Elizabeth Spencer Adams
49 Merrill Street
Portland, ME 04101

Re: 30 Merrill Street

October 4, 2016

ISSUE DATE 11/07/16
EMW
SHEET TITLE BSMNT / FIRST
SHEET SCALE 1/4" = 1'-0"

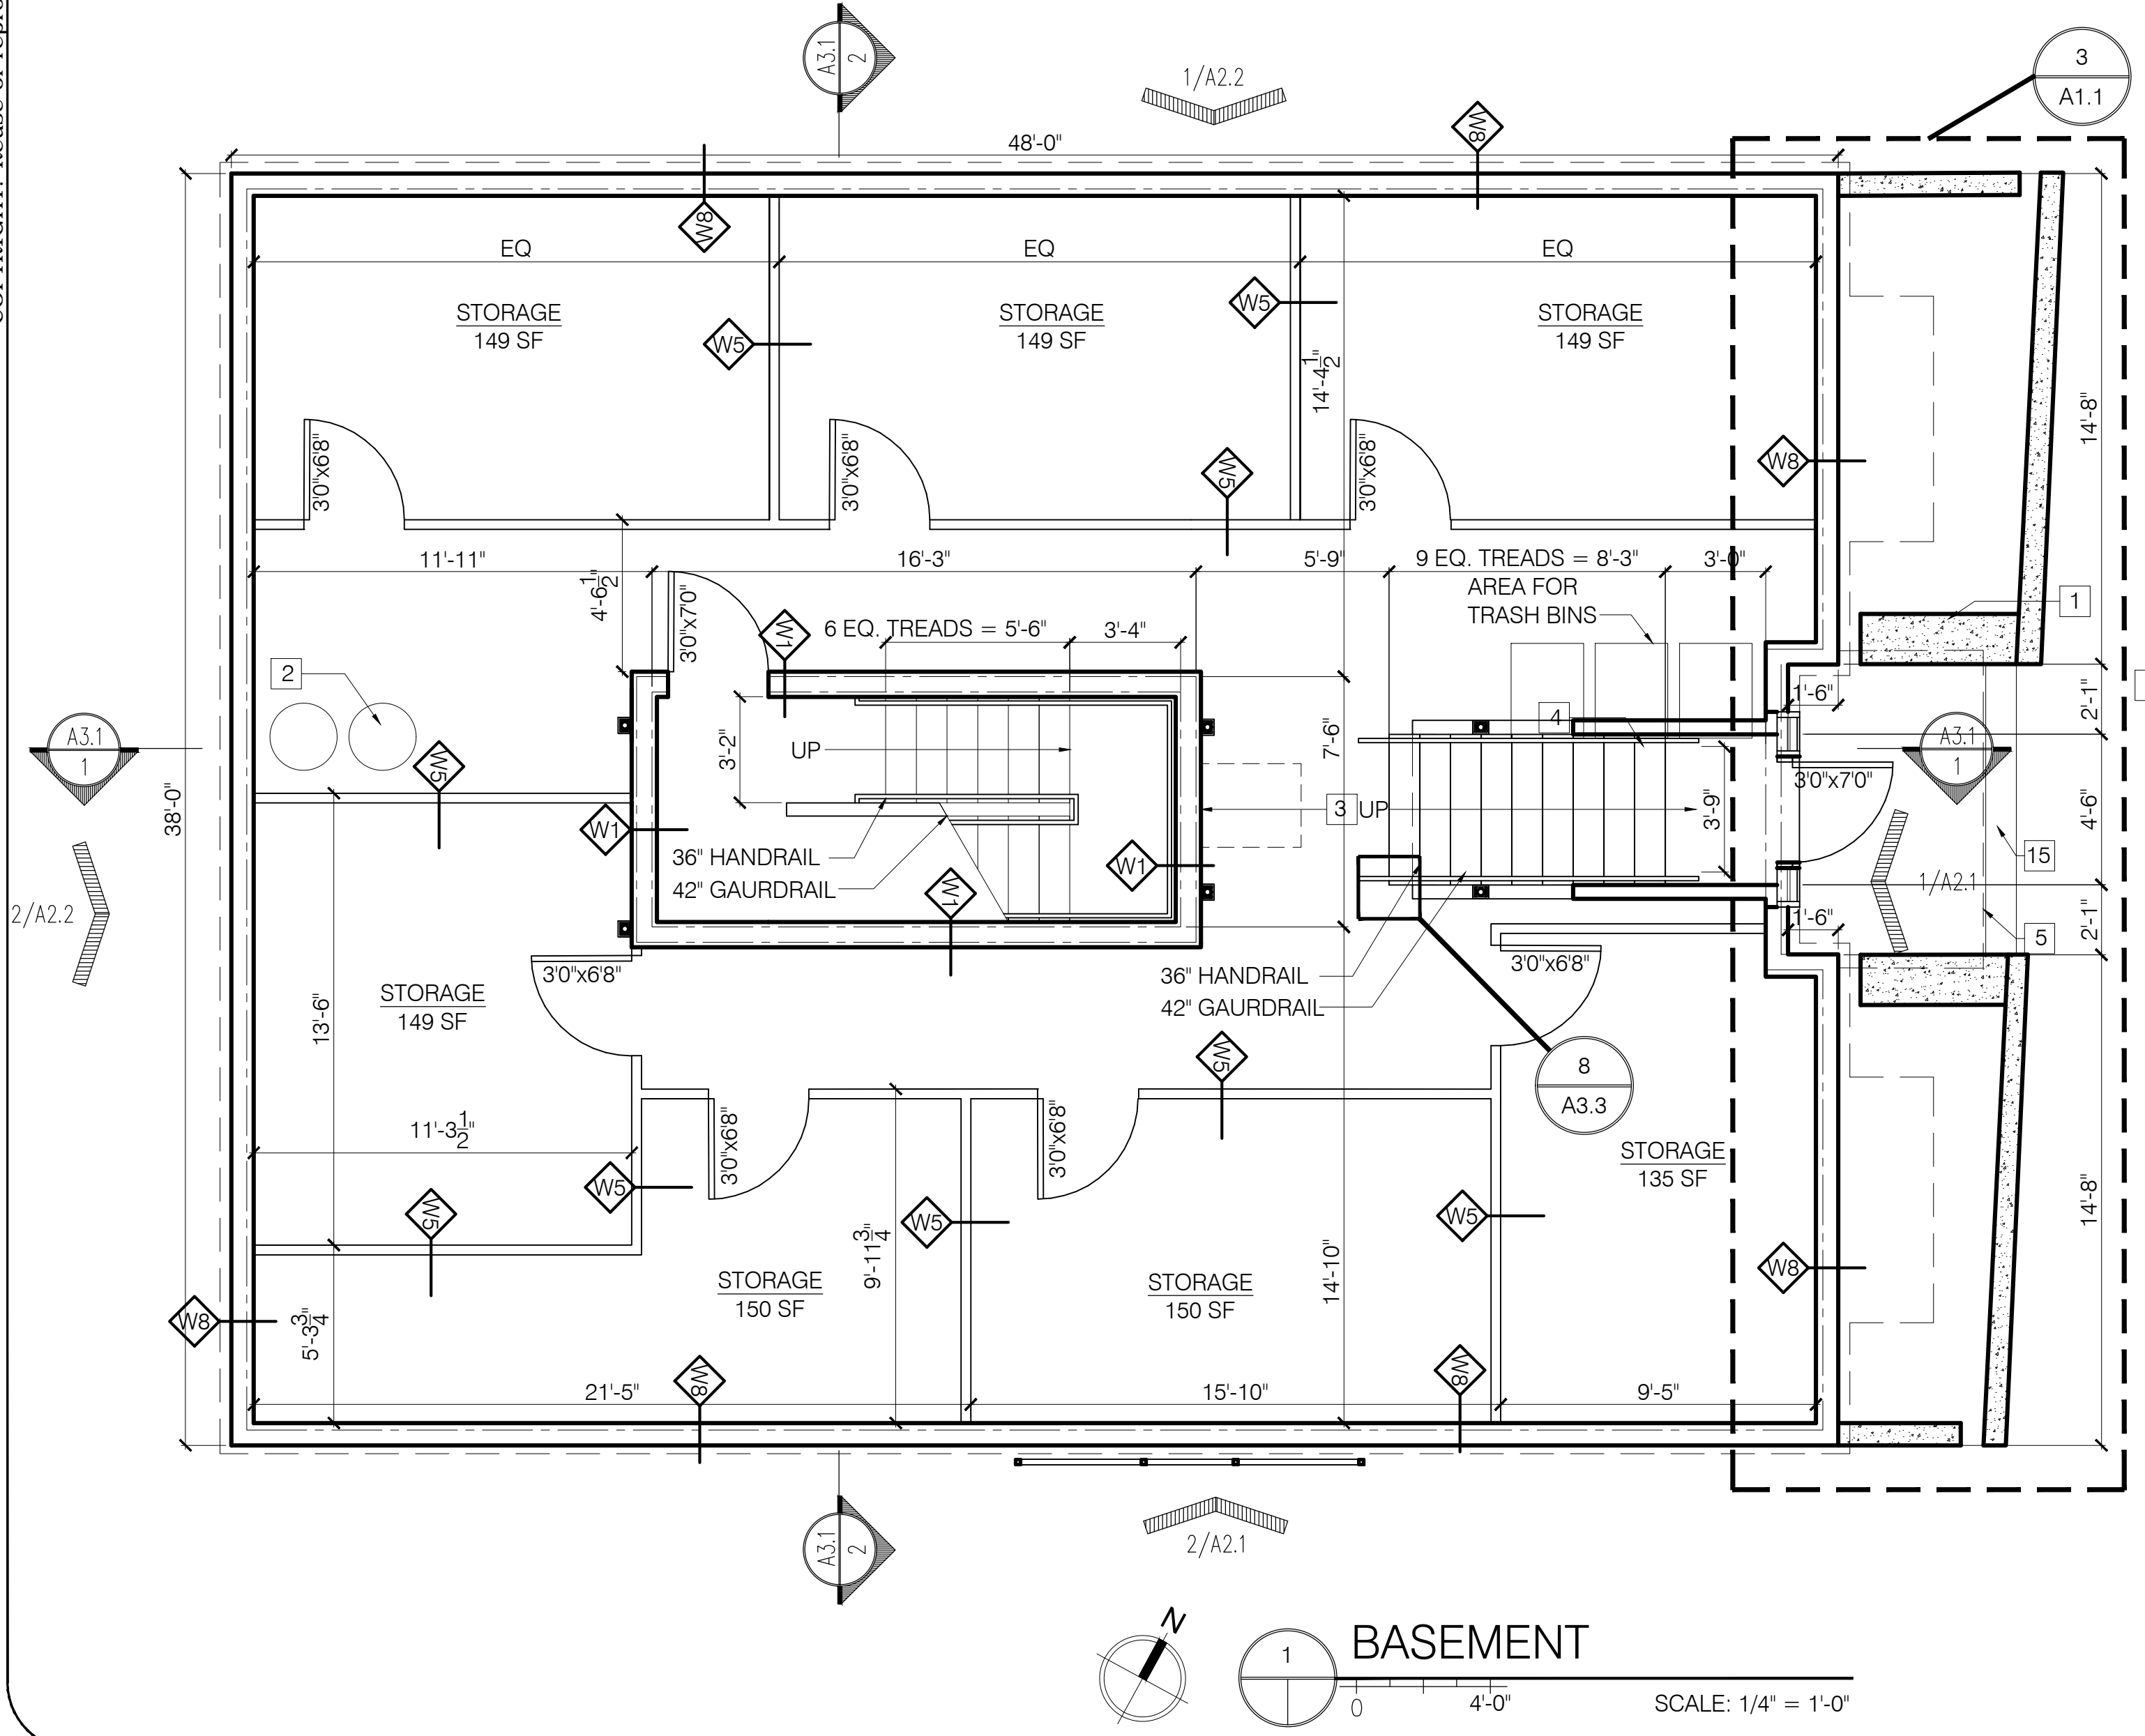
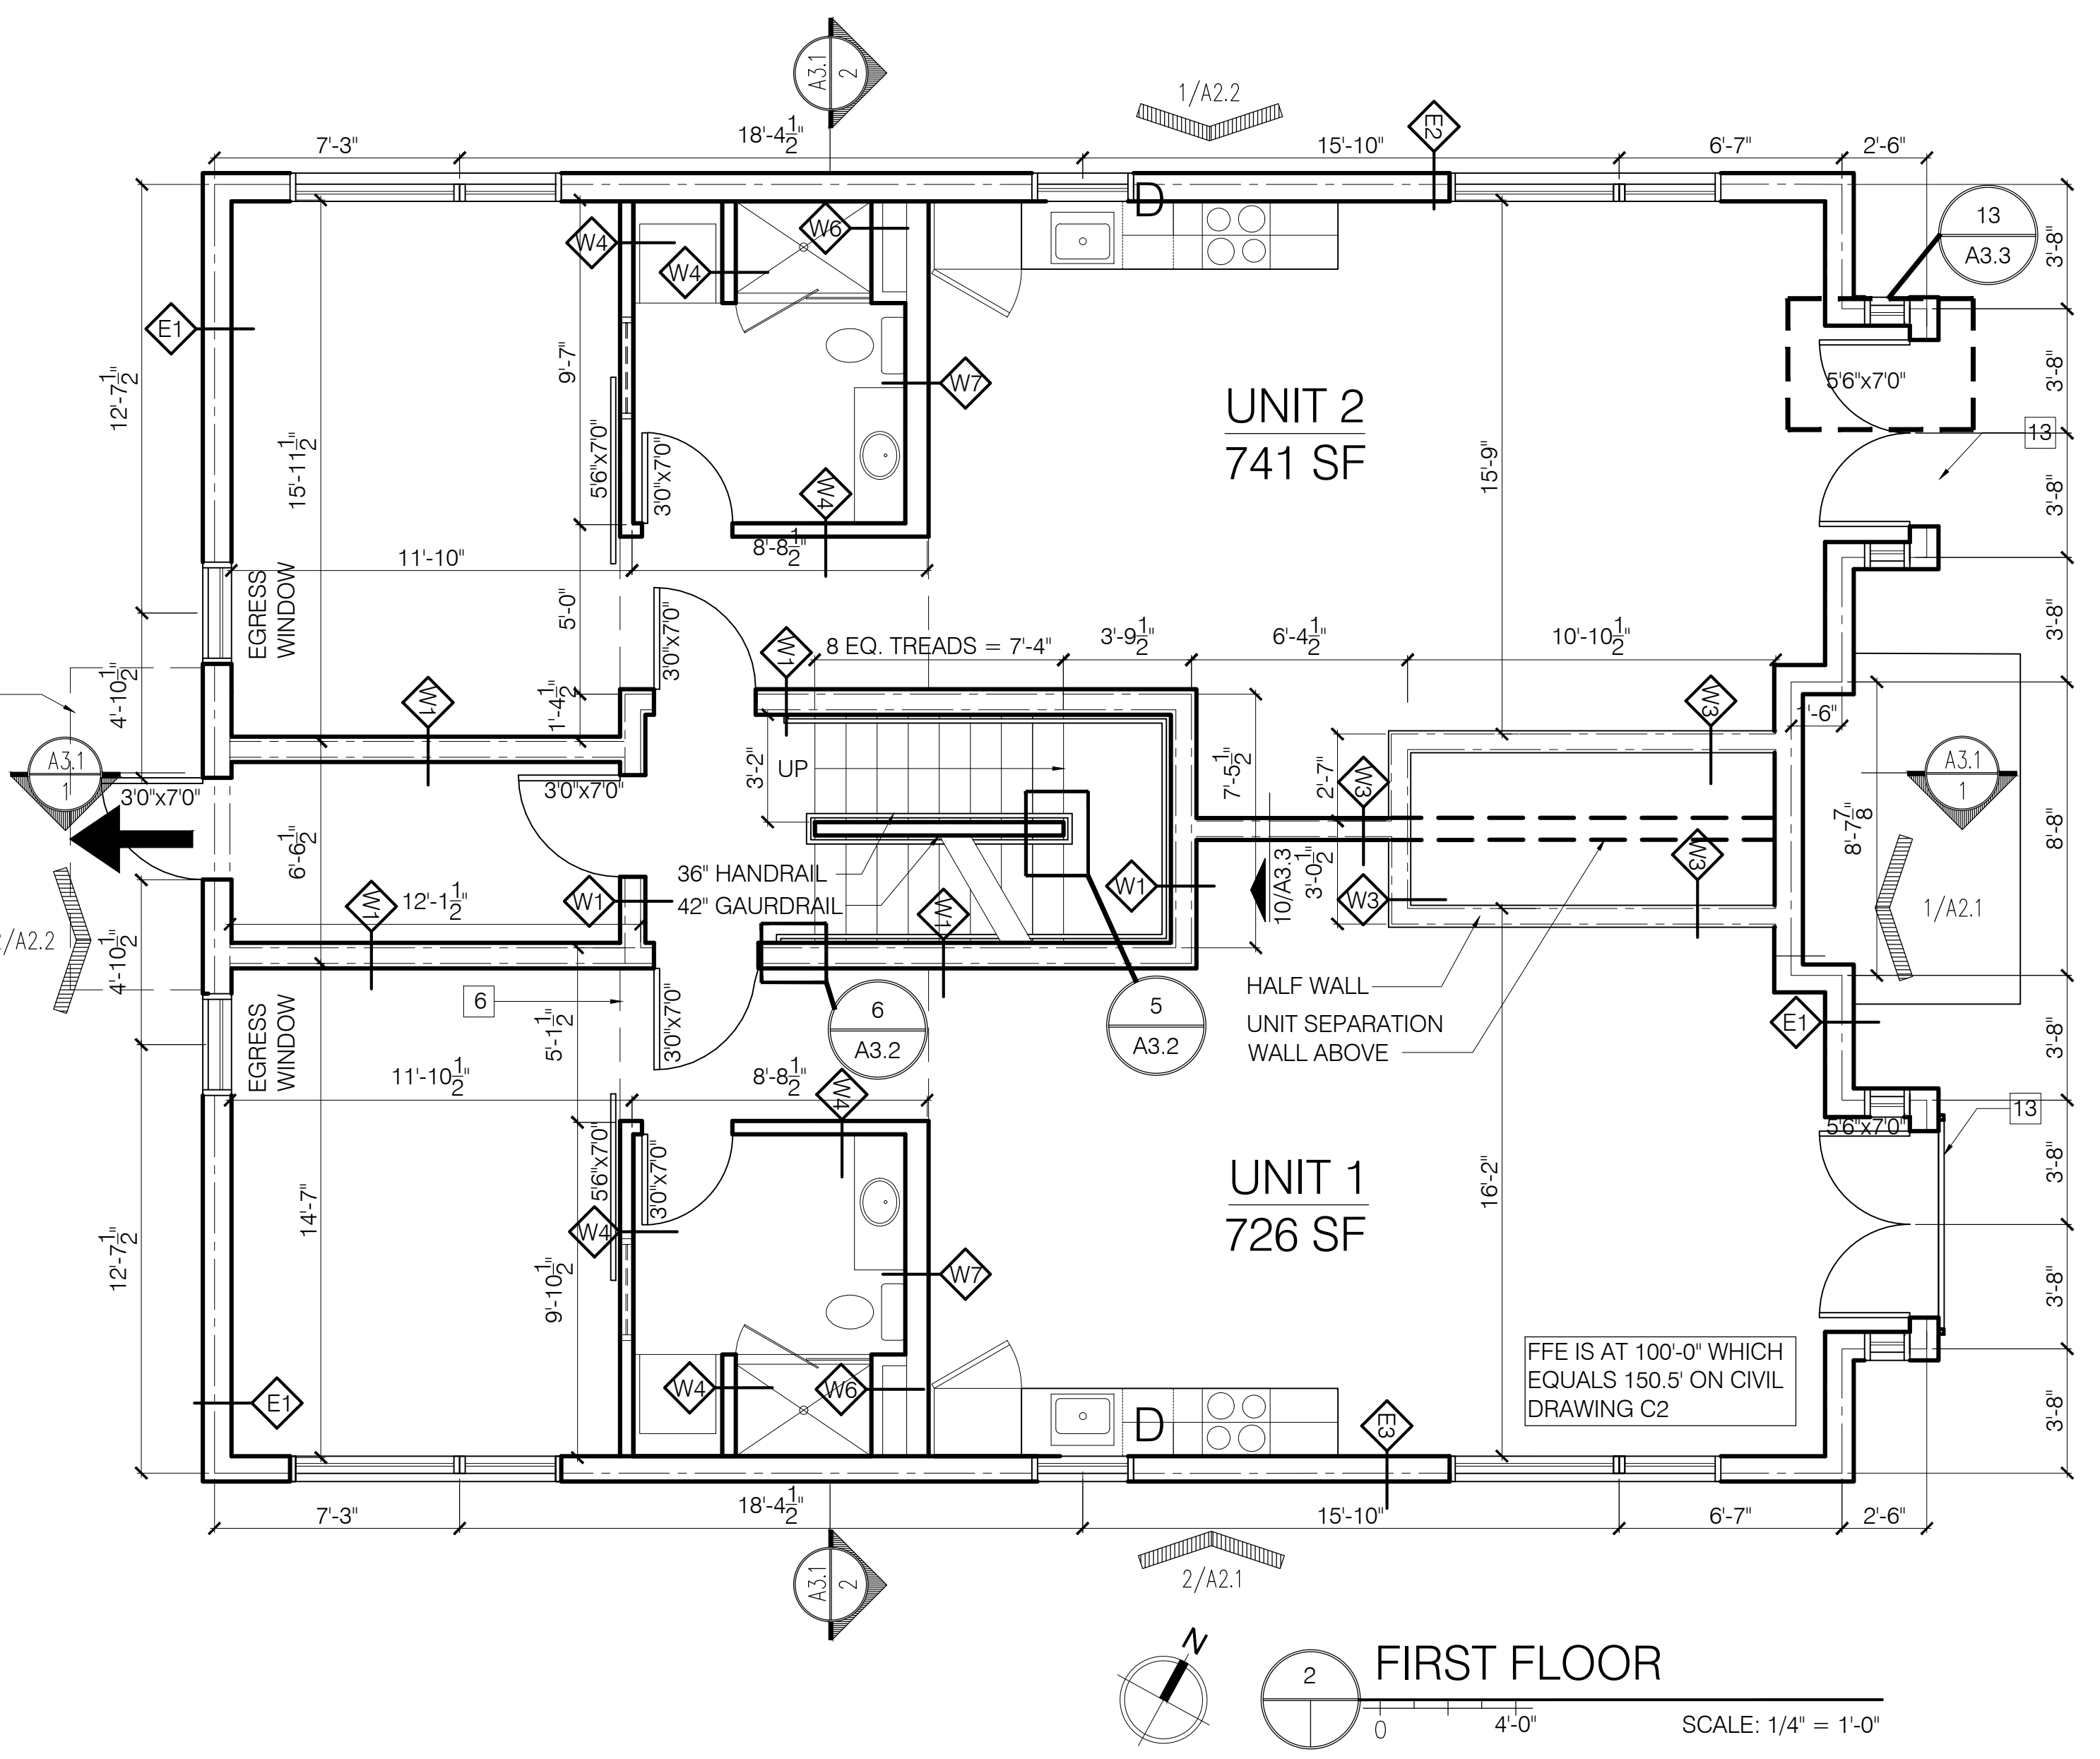
Design Standard C-1 states: "Emphasize and orient the main entrance to the street." The 30 Merrill design includes a minimally-enhanced "main entrance," which we learned at the neighborhood meeting is not a main entrance at all. In fact, it is an entrance to the basement that contains only storage areas for the units. It seems to be the argument that so long as it looks like a main entrance that is enough. It is not. There is a rationale behind this design standard that has been well articulated by numerous urban designers (Jan Gehl , Cities for Real People; Jane Jacobs, The Death and Life of Great American Cities; Christopher Alexander, A Pattern Language), planners and articulated in municipal standards. The rationales relate to the life of the street, community, walkability, and the safety of the inhabitants and passersby.

Standard C-1 requires that the main entrance either be at the front of the building or on a covered porch to the side that extends all the way to the front of the building. It makes a mockery of this design standard to interpret it to mean that something that looks like a front door is good enough. It also fails to add to the city's goal of walkability and health. Sam Newburg in his 2014 article "Front Doors and Walkable Cities" writes:

The current design cannot even attempt to pass the test of "be[ing] comfortable walking in and out of that door every day" because it is not actually a main entrance that one will walk in and out of on any regular basis. That it might be dressed up to look like a main entrance is most definitely not good enough.

Finally, on this point of where the true main entrance is sited, the requested waiver for a narrowed driveway aisle makes stopping to visit even less likely for a resident who must take care not to be hit by a fellow resident turning into or coming out of the driveway. Many design standards require a full walkway in the event that an entrance to a building is at the back so people coming and going are not walking along a driveway. Not having a walkway is bad enough; narrowing the driveway is clearly unsafe.
